Our Reference: SYD20/01146/03
Departments Reference: SSD-9794683

RESPONSE TO SUBMISSIONS - OAKDALE WEST ESTATE STAGE 3 - WAREHOUSES 2A, 2C, 2D, 2E - 2 - 18 ALDINGTON ROAD, KEMPS CREEK

Attachment A – TfNSW response

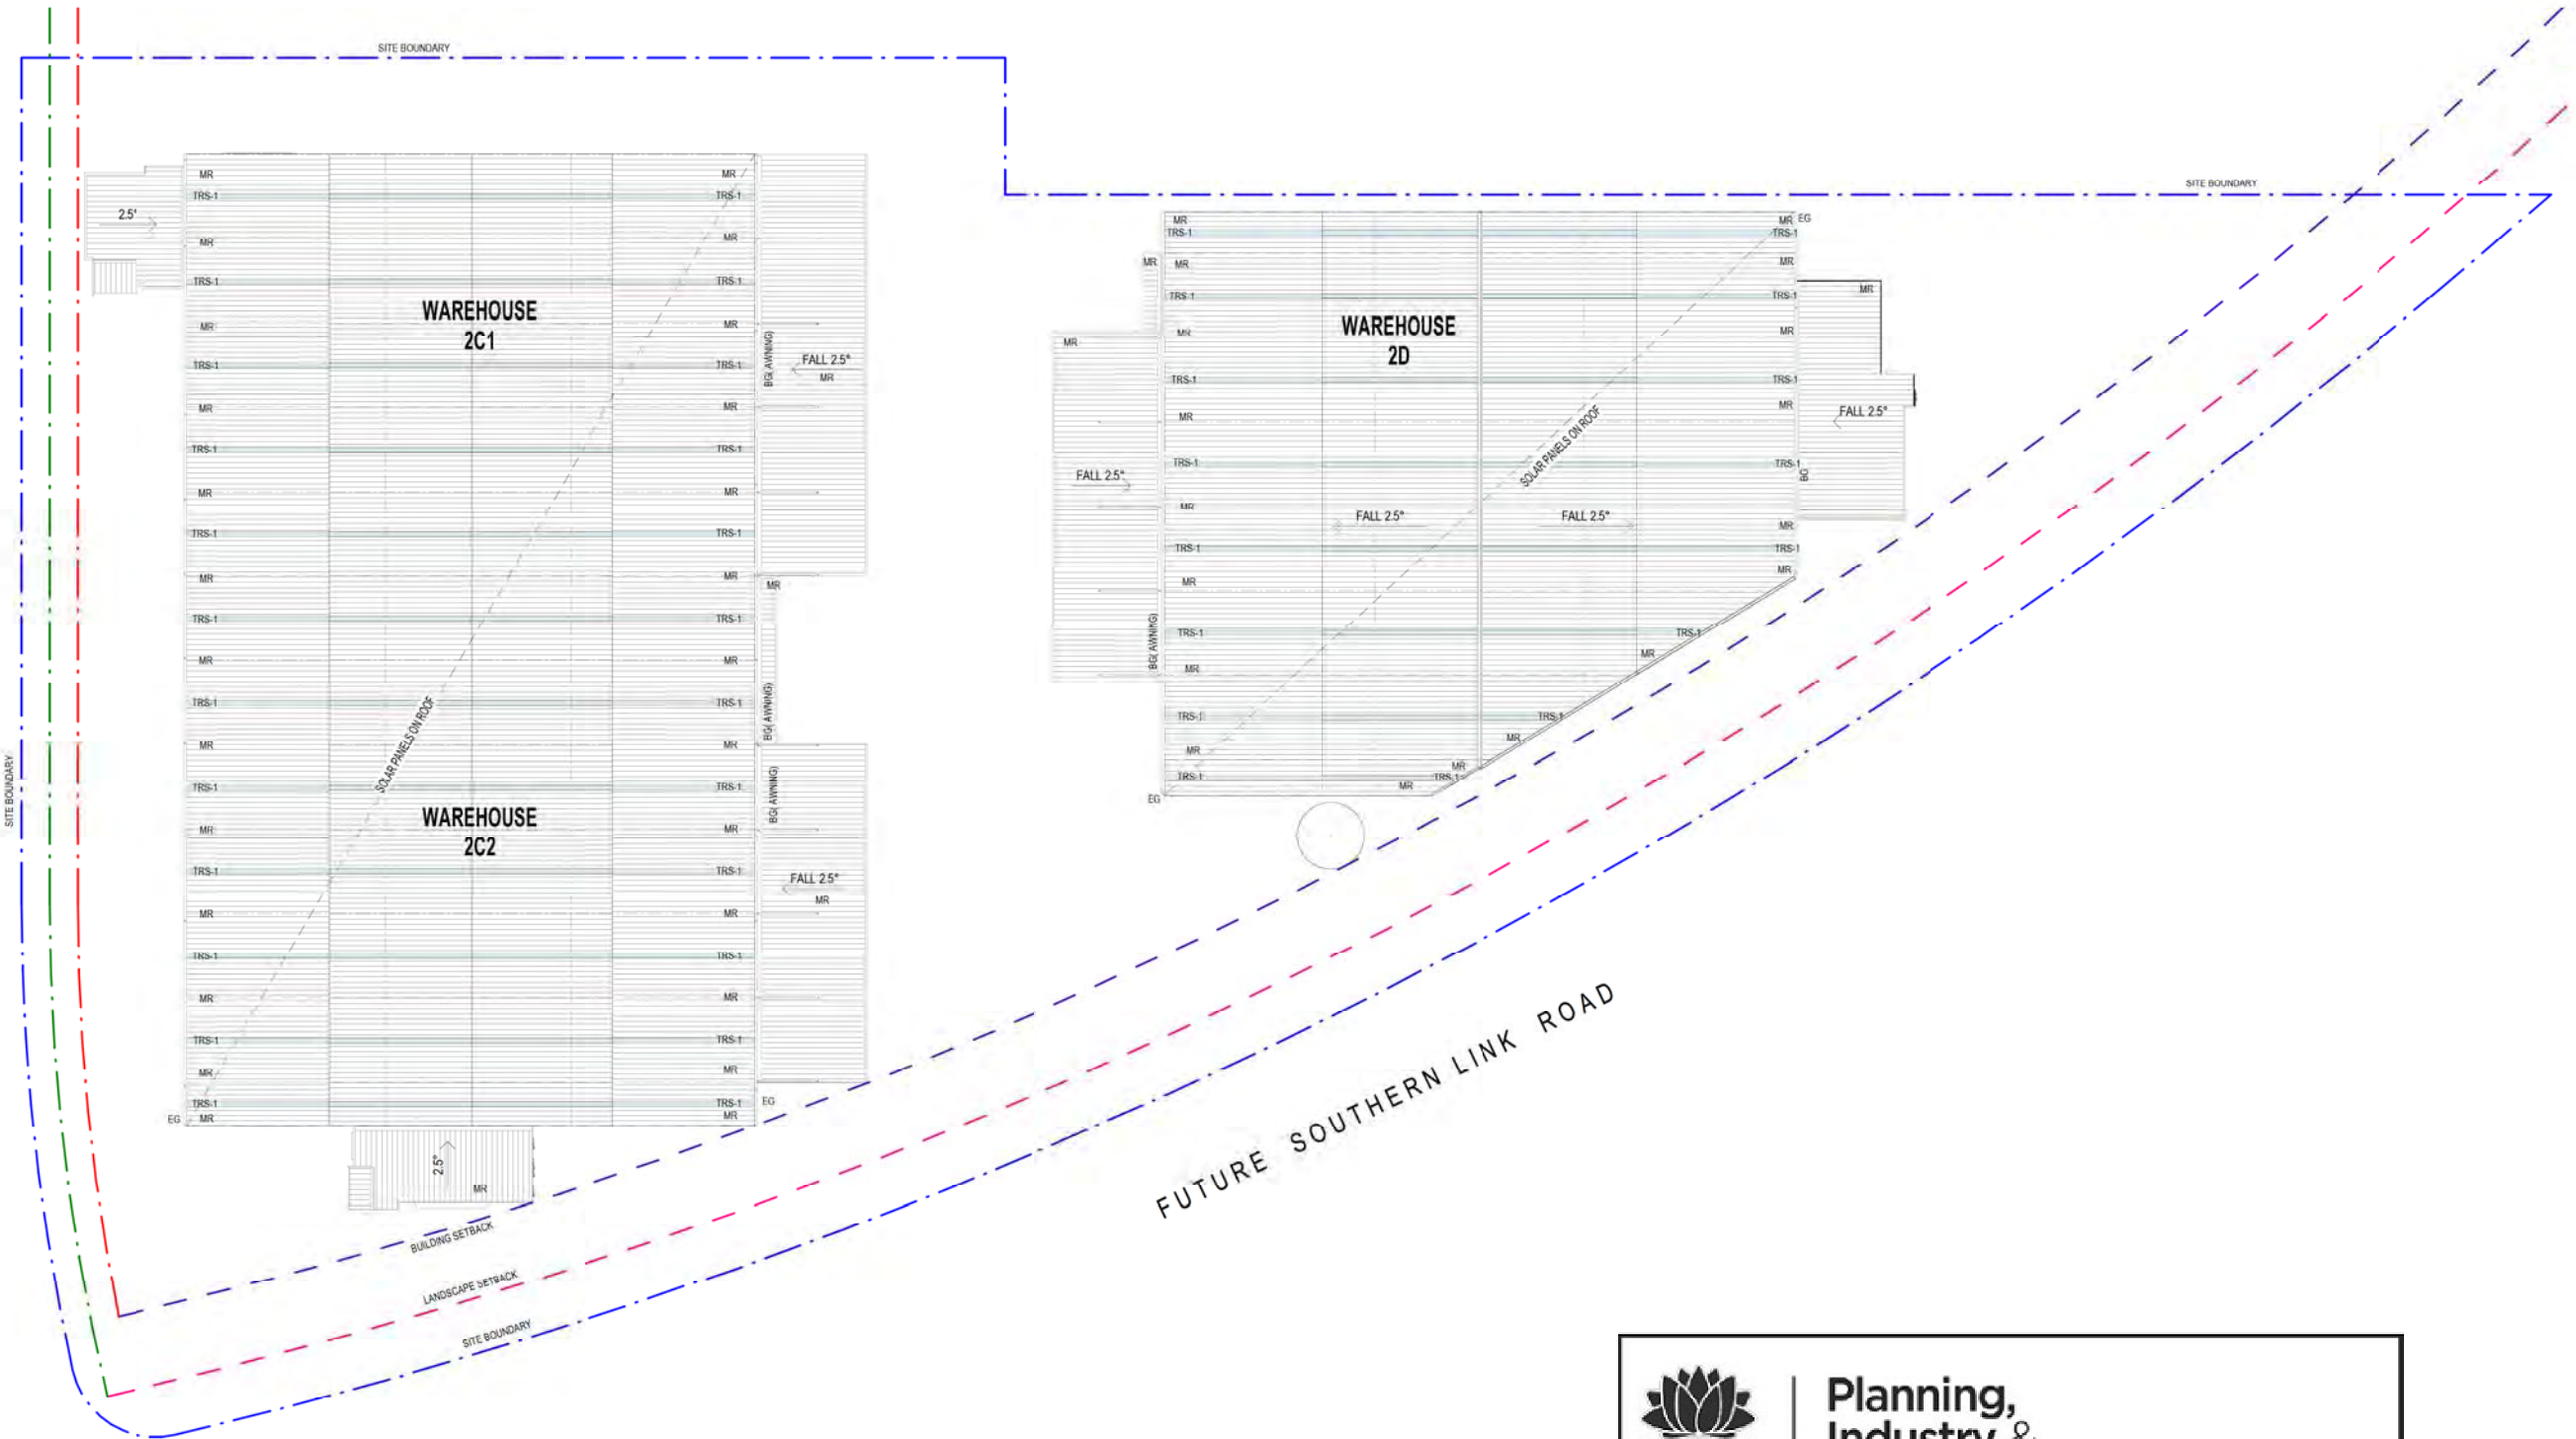
In the Response to Submissions, the proponent has provided some justification regarding the access to building 2C remaining at the proposed location. Whilst TfNSW understands that the modelling indicates a queue length of 63 metres, the location of the access is not supported. Direct access to the collector roads should be kept to a minimum and away from major intersections to support traffic efficiency and to reduce conflict points along collector roads.

The swept path plans for building 2C indicate that simultaneous entry/exit cannot be achieved with the largest vehicle from Estate Road 01. The location of this access point is close to the intersection of the SLR and could lead to queuing on the collector road where 2 opposing vehicles are attempting to use the access at the same time. This could affect through movements and cause congestion at the intersection with SLR.

It is recommended that the access for vehicular parking for building 2C be relocated north as far from the intersection with the Southern Link Road (SLR) as possible to reduce fragmented road side activity near key decision points.

It is recommended that the design of the access point allows for simultaneous entry/exit movements of the largest vehicle. The swept path of the longest vehicle entering and exiting the subject site, shall be in accordance with AUSTRROADS.
